**OBJECTION TO SSD 93020230 40-48 REDAN STREET, MOSMAN
PROPOSED DEMOLITION WORKS AND CONSTRUCTION OF A PART 10-STOREY AND
PART 5-STOREY PROPOSED RESIDENTIAL FLAT BUILDING CONTAINING 53
RESIDENTIAL DWELLINGS (INCLUDING 11 AFFORDABLE HOUSING UNITS) WITH 2
LEVELS OF BASEMENT PARKING CONTAINING 106 RESIDENT PARKING SPACES
APPLICANT: MOSMAN LAND NO. 1 PTY LTD**

State Planning Services Pty Limited (**SPS**) has been commissioned by Hamid and Mastaneh Daghighi, owners of No. 77C Redan Lane, Mosman (**our clients**) to provide an independent town planning assessment of SSD 93020230 (**the proposal**) at Nos. 40-48 Redan Street, Mosman (**the site**).

Figure 7 Correct Measurement of Green Line in Figure 13 of TIA relied upon by the EIS

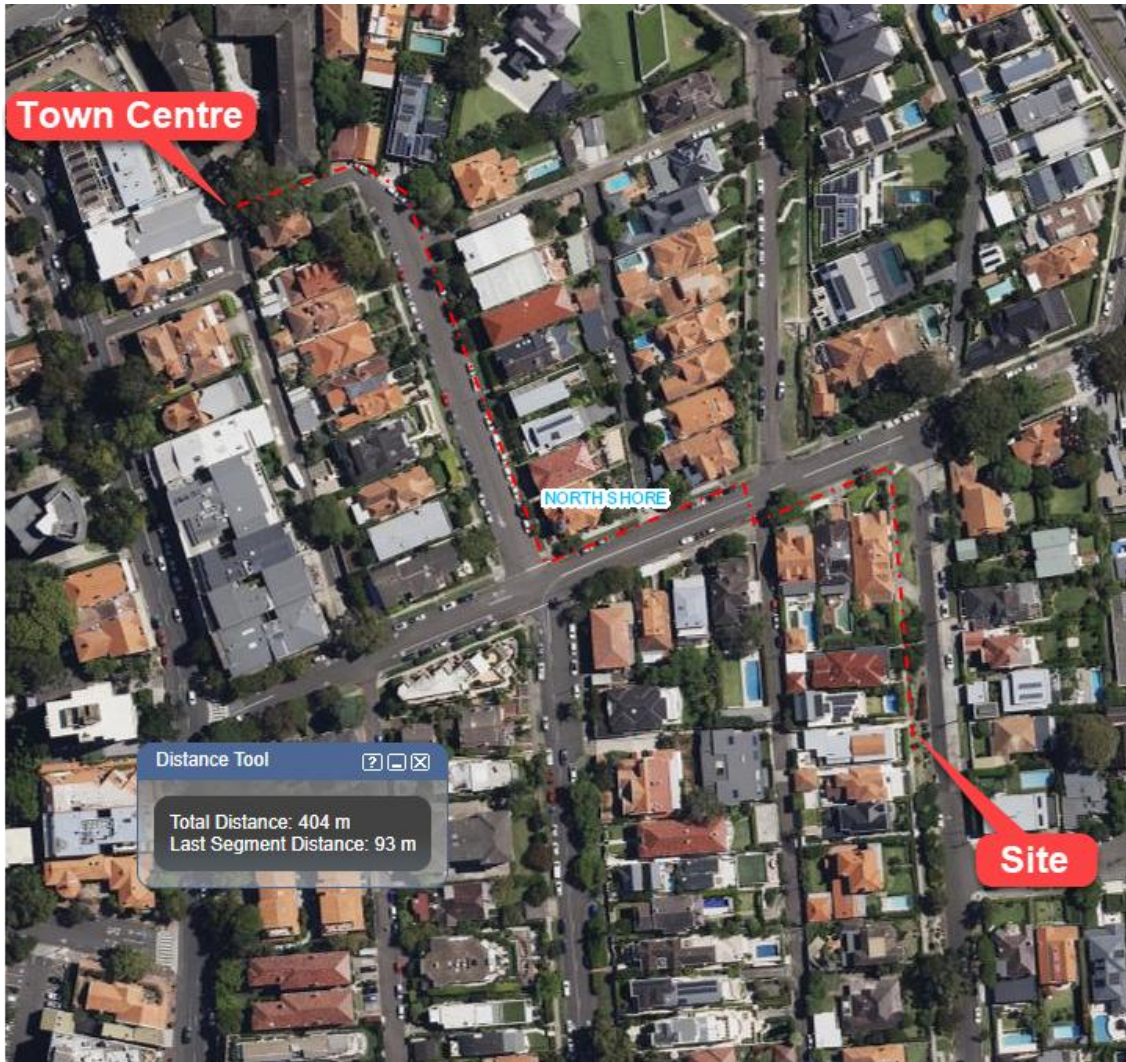
JMT Consulting describes the route in the TIA and states '*As advised by LTS Surveyors this walking route has a total distance of 394.7m to the nearest 0.1m.*' Although the walking route assessment in the TIA does not rely upon Redan Lane, the measurement of 394.7m is incorrect as the correct measurement of the green line in Figure 13 of the TIA is 404m (**Figure 7**).

Although the TIA does not purport to rely upon Redan Lane as part of any walking route, the EIS nevertheless appears to rely upon an incorrect measurement of 394.7 metres, which has been used to falsely characterise the site as falling within a 'low and mid rise housing inner area' (as defined).

Figure 9 Spit Junction Town Centres map – Extract with SPS Mark-up in Red

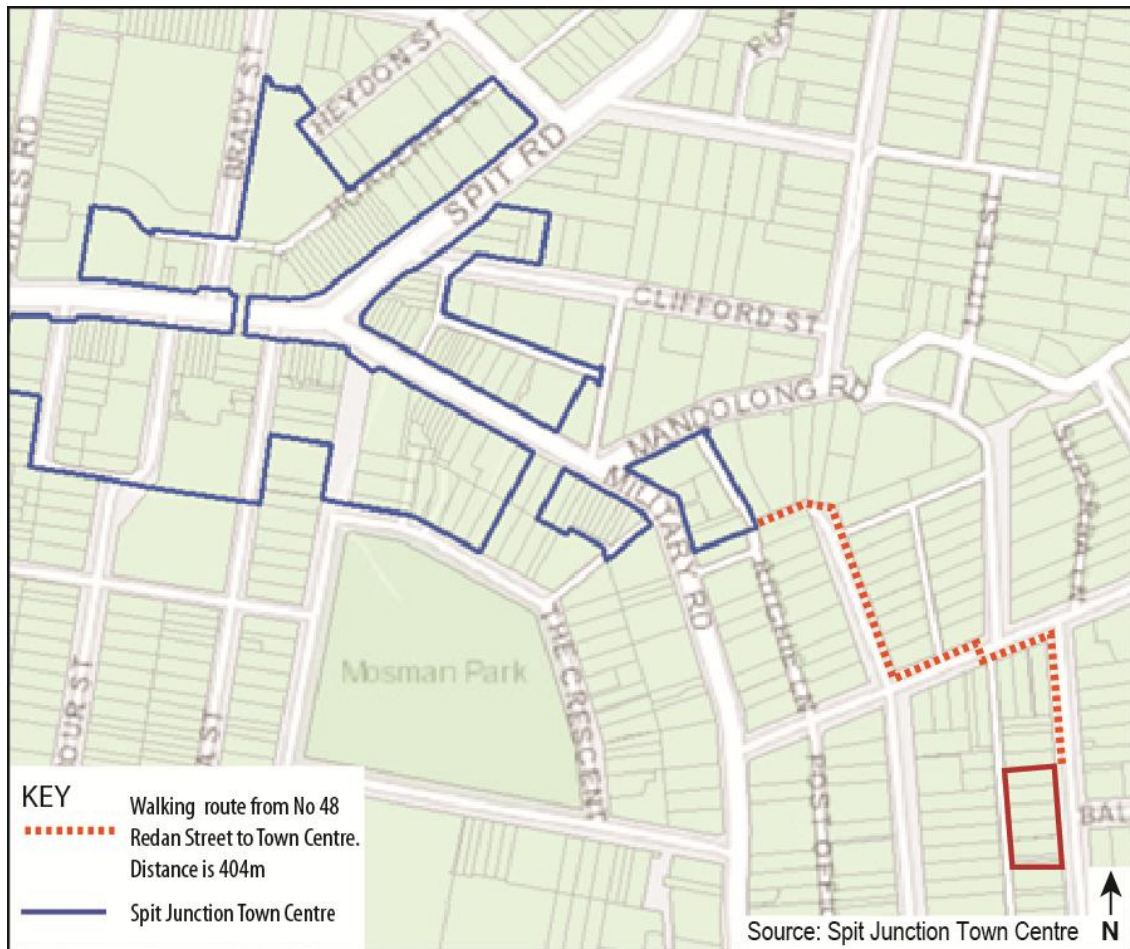
Whilst the site is within a low and mid rise housing area, it exceeds 400m 'walking distance' of the Spit Junction Town Centre and therefore is appropriately categorised as a low and mid rise housing outer area.

Even without using the available pedestrian crossing and by disregarding slope, the site is measured well in excess of 400m from the edge of the nominated Spit Junction Town Centre via the footpaths that can be safely walked by a pedestrian to the Redan Street frontage.
